Appeal Decision

Appeal Ref: APP/R5510/W/23/3333357

Dellfield Uxbridge Road, Hillingdon, Uxbridge UB10 0PL

- The appeal is made under section 78 of the Town and Country Planning Act 1990 (as amended) against a refusal to grant planning permission.
- The appeal is made by Mr Amandeep Singh against the decision of the Council of the London Borough of Hillingdon.
- The application Ref is 65993/APP/2023/2146.
- The development proposed is to demolish existing house (Dellfield) to replace with new house, and create 3 new houses on backland.

DRAWING
TITLE
House Type 2:
Floor plans &
Elevations

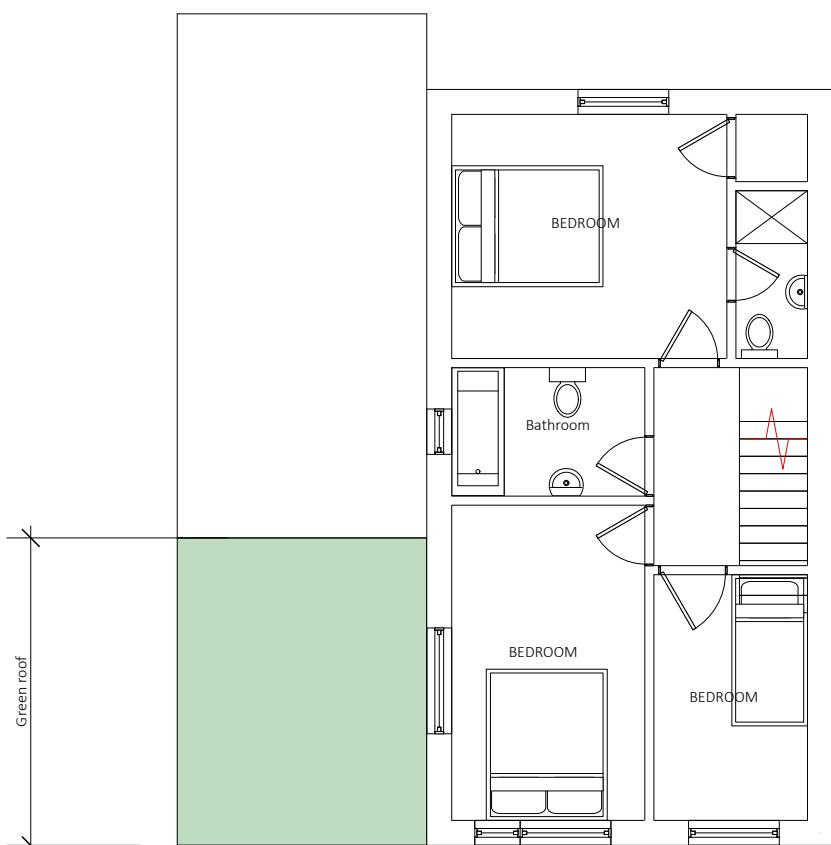
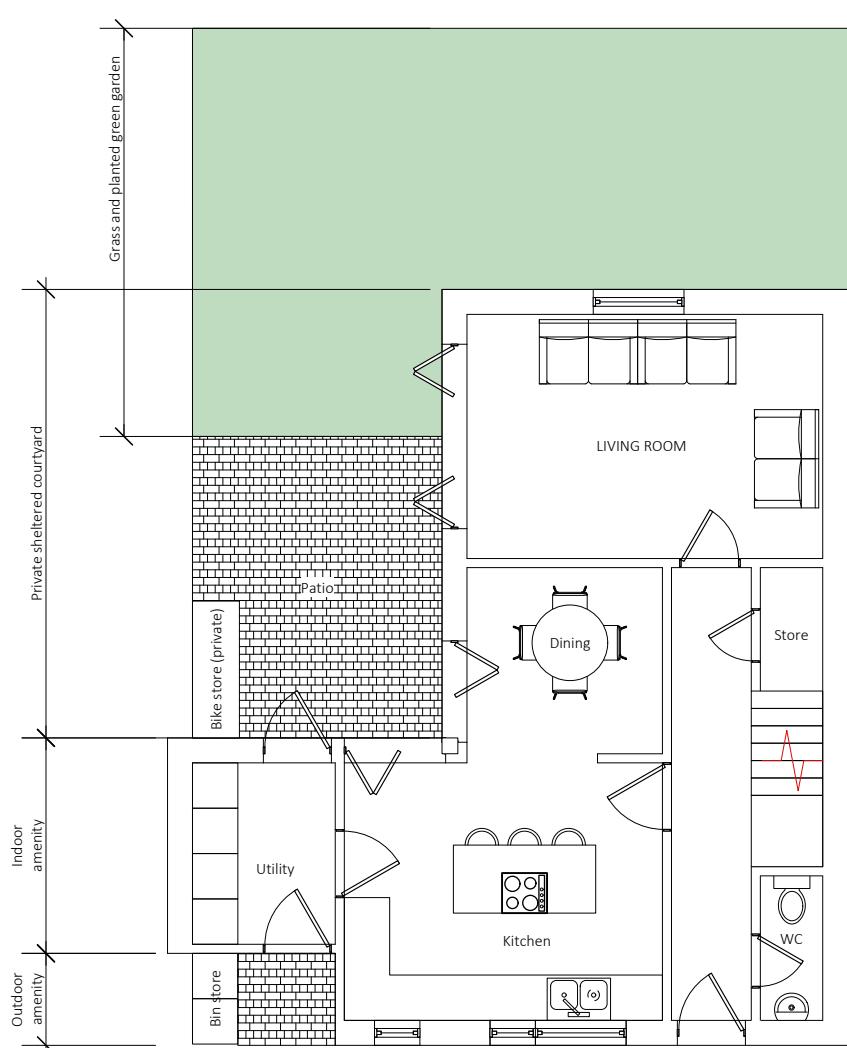
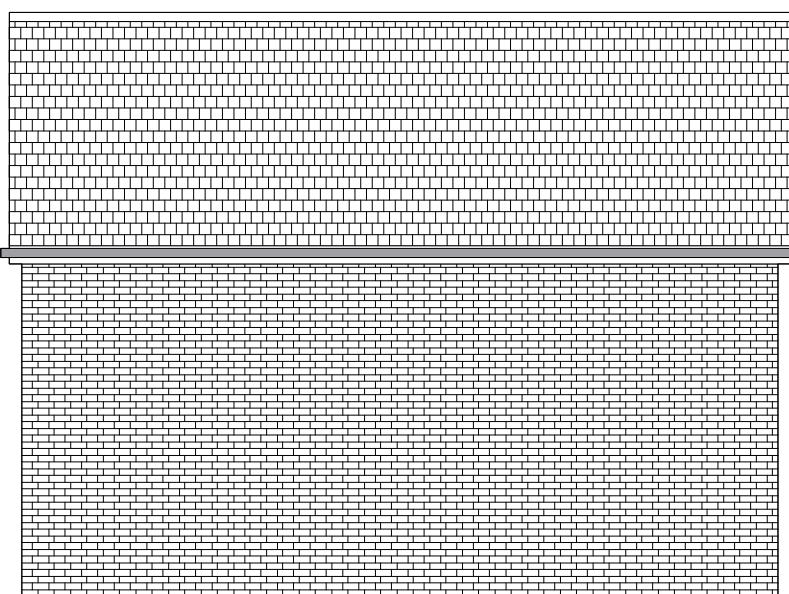
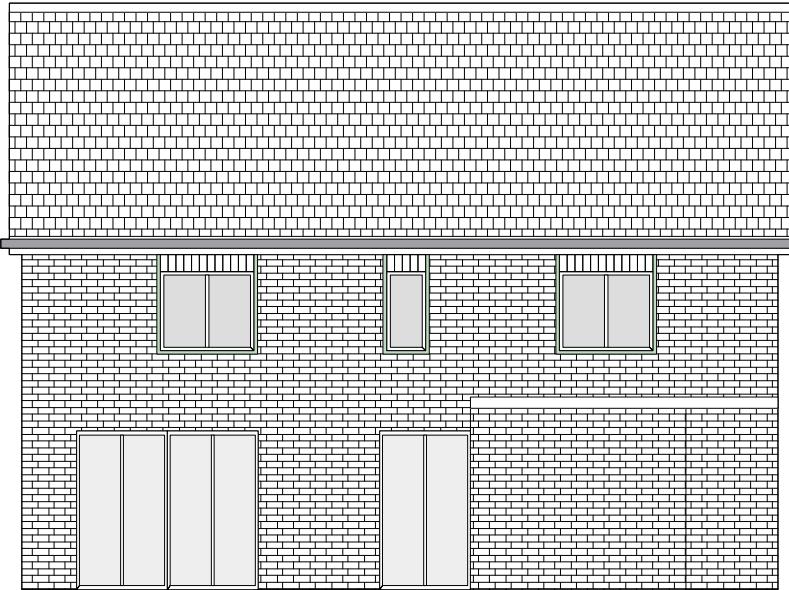
21. The three two storey properties proposed within the rear curtilage of Dellfield would be arranged in a row, with the flank elevation of House 2 in close proximity to the back of the rear boundary of Leederville. The appeal site is lower than this neighbour and some groundworks are proposed to lower the land within the appeal site further. These factors combined result in the ridge height of House 2 being marginally lower than Leederville.
22. While I acknowledge that House 2 has been designed in order to minimise the impact of the development on Leederville, the proposed dwellings in the rear garden area are significantly larger than a typical ancillary garden building. The occupants of Leederville currently benefit from an open area beyond the bottom boundary of their rear garden. The proposal would result

in development along the entirety of the bottom of their rear garden which would be significantly higher than the boundary. As the rear garden of this property is relatively short there would be only a minimal separation distance between this neighbour and House 2. Given the close proximity and scale and massing of the proposal, it would result in a sense of enclosure and have an overbearing impact on the occupants of Leederville irrespective of its orientation in relation to this property.

PROPOSED STREETSCENE @ 1:200

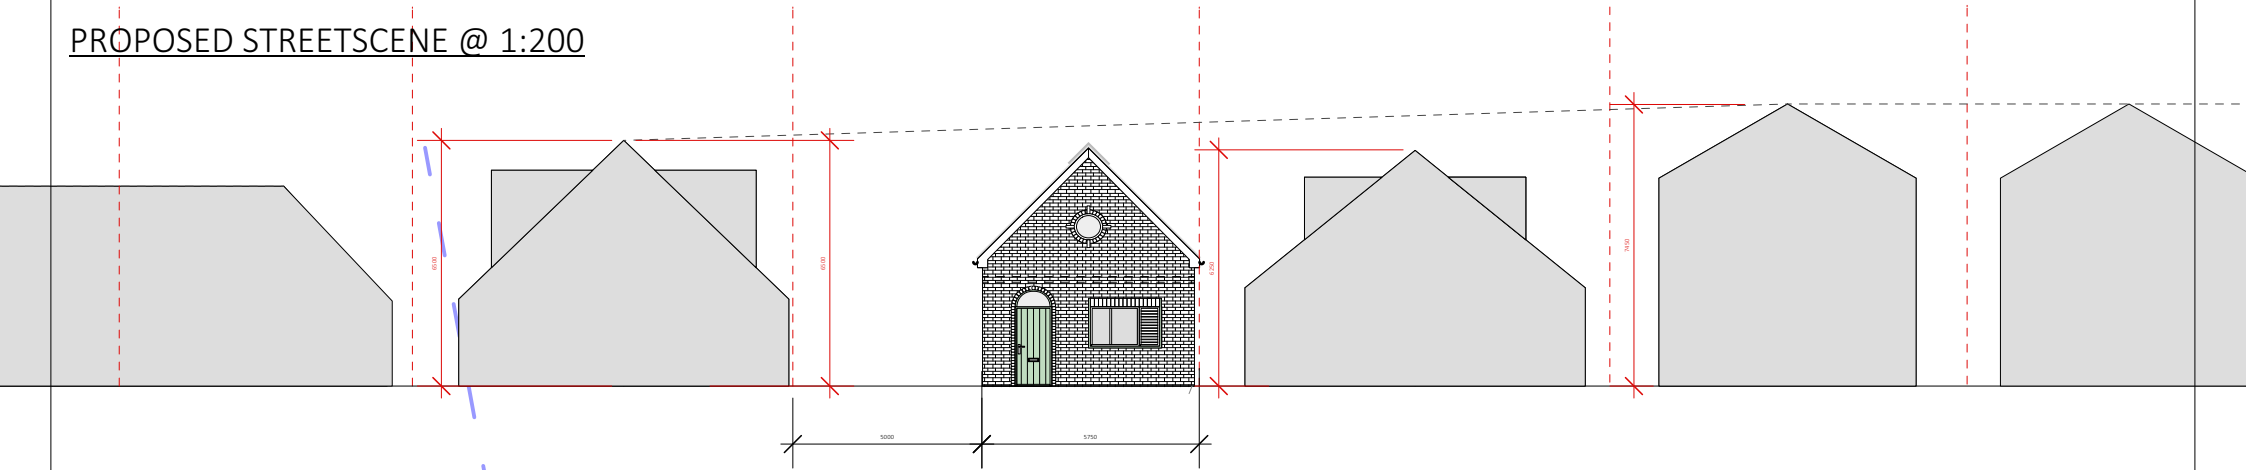
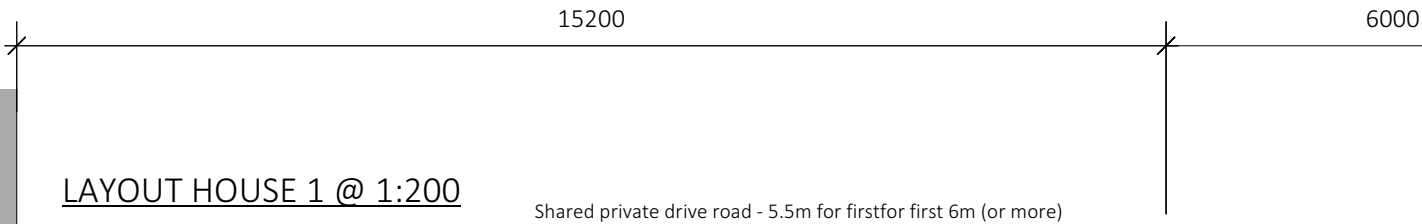
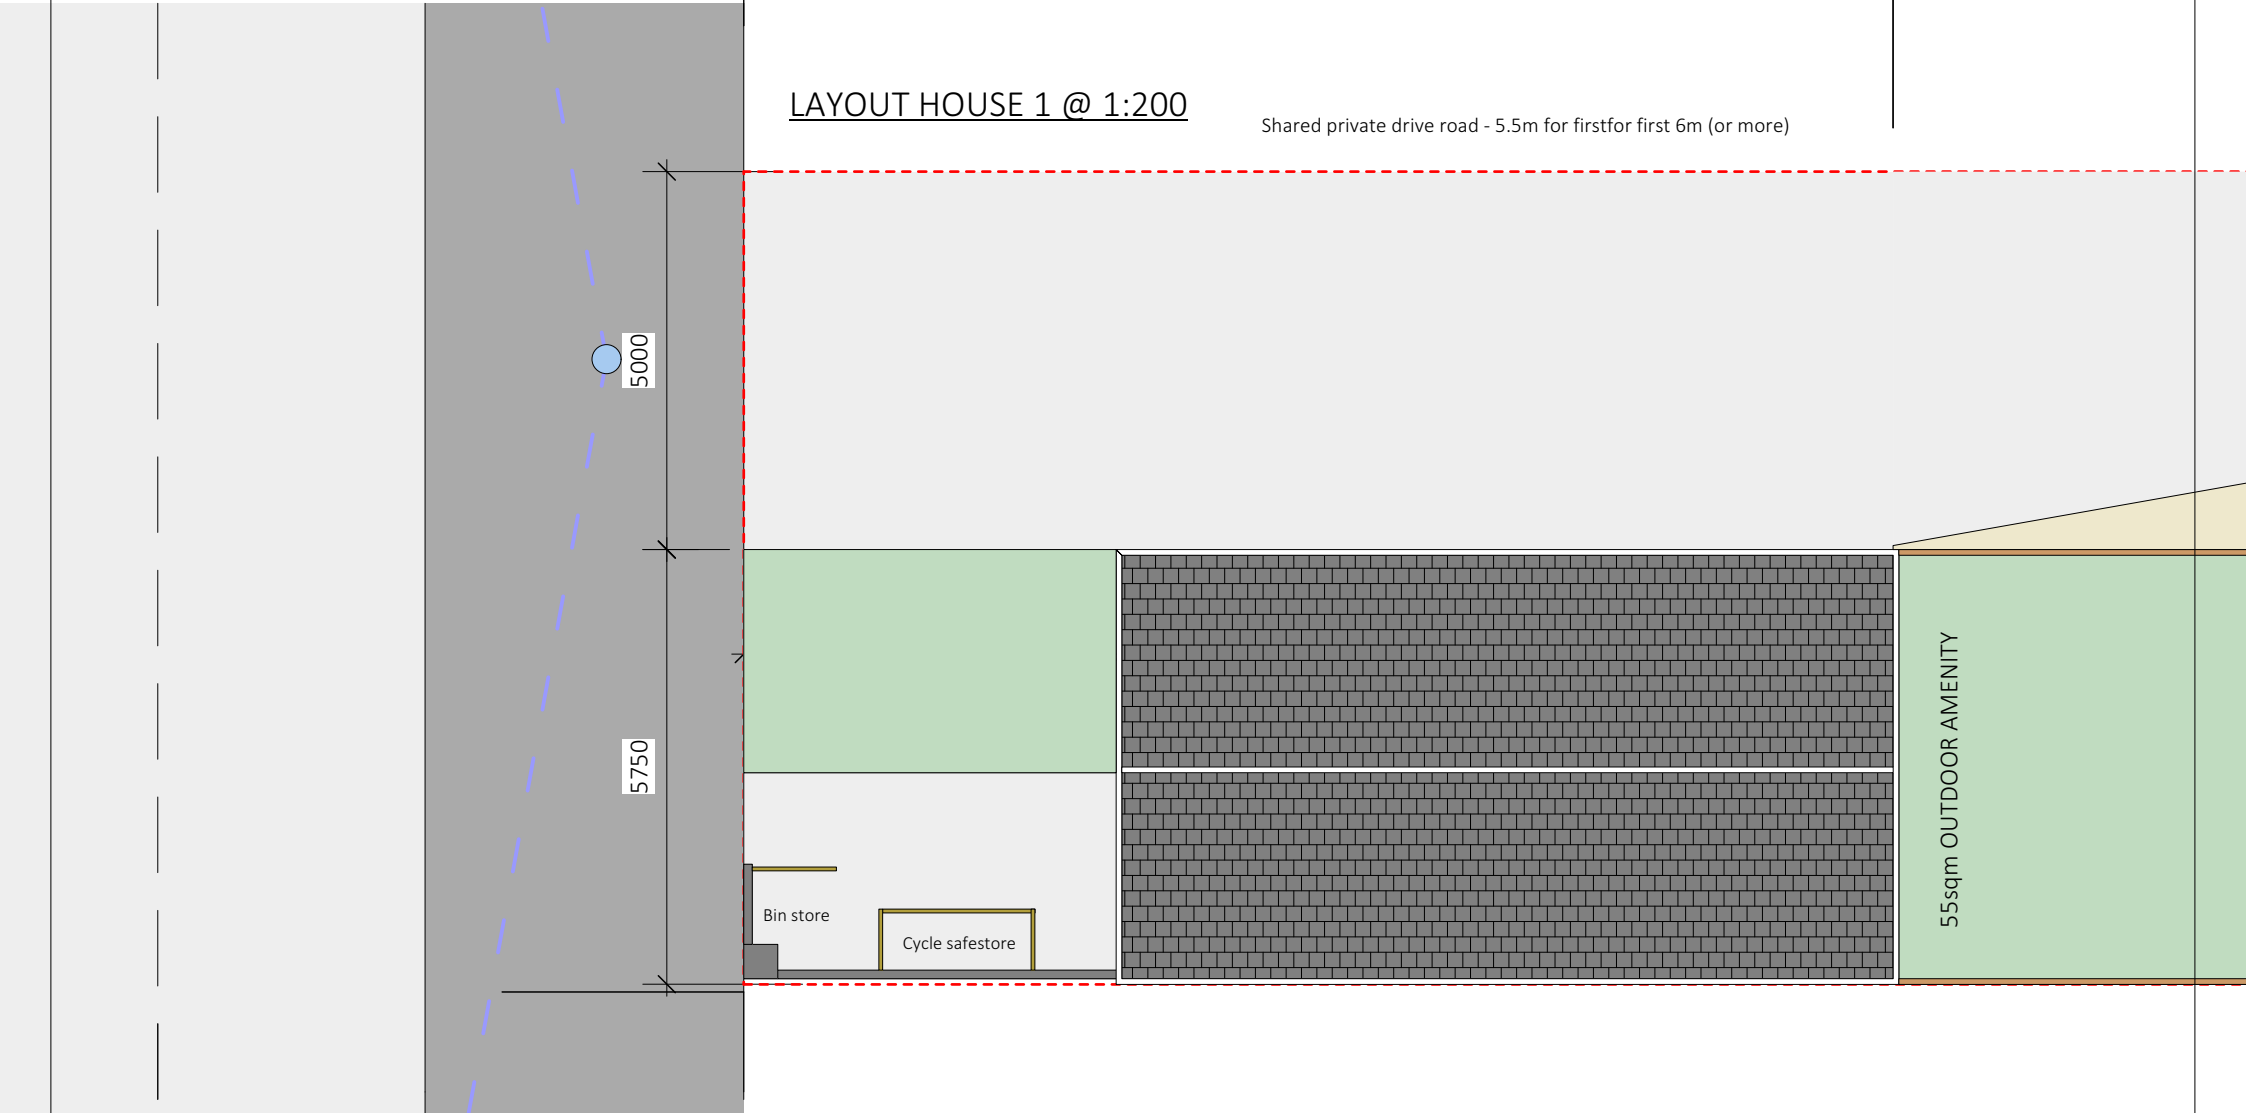
8. Criteria ii within Policy DMH 6 of the LPP2 discourages the formation of access roads to backland and garden development sites between dwellings and stipulates that vehicular access and parking should not have an adverse impact on neighbours in terms of noise or light. I will assess the impact of the access on living conditions in greater detail below. In terms of character and appearance, the formation of a vehicular access between neighbouring property Leederville and the proposed House 1 would not reflect the established pattern of development, which is characterised by dense frontage development and as such would not be well integrated with the surrounding area.

11. The proposed replacement dwelling would reflect the established building line and the height and design would echo the neighbouring properties on either side. However, its width would be significantly narrower than Dellfield, and would not reflect the established built form in the area which comprises of dense built up frontage development with a horizontal emphasis.

16. The scheme includes a long vehicular access road that would run directly past the side elevations of both Leederville and the proposed replacement house (House 1).

18. Further, as the gap between House 1 and Leederville would be utilised entirely by the access road, there would be a minimal separation between vehicles accessing the properties to the rear of the site and the flank elevation. This close proximity to the access would mean that the occupants of House 1 and Leederville would be subject to the noise and disturbance of vehicles utilising the access. It is likely that the occupants of these properties would be subject to a greater degree of noise and disturbance which would erode the sense of calm and tranquillity associated with the garden land as existing, resulting in a material degree of harm to the living conditions of the existing occupants of Leederville and the future occupants of House 1 in terms of noise and disturbance.

26. The proposed scheme would include an access within the bus stop cage area, which would serve the three properties proposed within the rear garden area. Each of these properties would have a single parking space and the proposed replacement dwelling would be car free. Based on the information before me the end of the access includes an 8m x 8m turning head.

29. The submitted plans do not include a swept path analysis or technical information to demonstrate the acceptability of the turning area under current legislation. The majority of the proposed access road would be 5m wide, which would be too narrow to allow two cars to pass each other easily. As such it is likely that the access and parking arrangement would result in instances where drivers would need to wait on the highway for the access to be clear or reverse on to the highway to clear a path for other users of the access, resulting in an access that is not safe or efficient.
